Application for Planning Permission. Town and Country Planning Act 1990

Number	
Suffix	
Property name	26-28
Address line 1	Dowding Road
Address line 2	
Address line 3	
Town/city	Uxbridge
Postcode	UB10 0RH
Description of site location must be completed if postcode is not known:	
Easting (x)	506730
Northing (y)	184131
Description

Change of use to category F1a small independent school.

GROUND FLOOR (CURRENT AND PROPOSED)

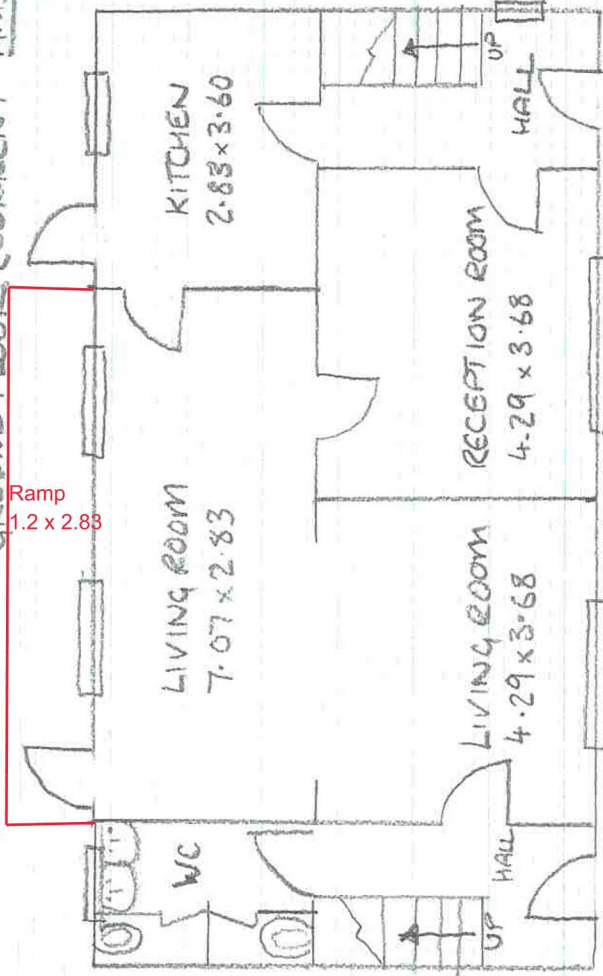
There is no information in regard to the provision of outdoor facilities, access arrangements for staff/pupils with disabilities and the type of education that it to be provided. Furthermore the plans are confusing because you are proposing living room spaces on the ground floor? What is the purpose of the living space?
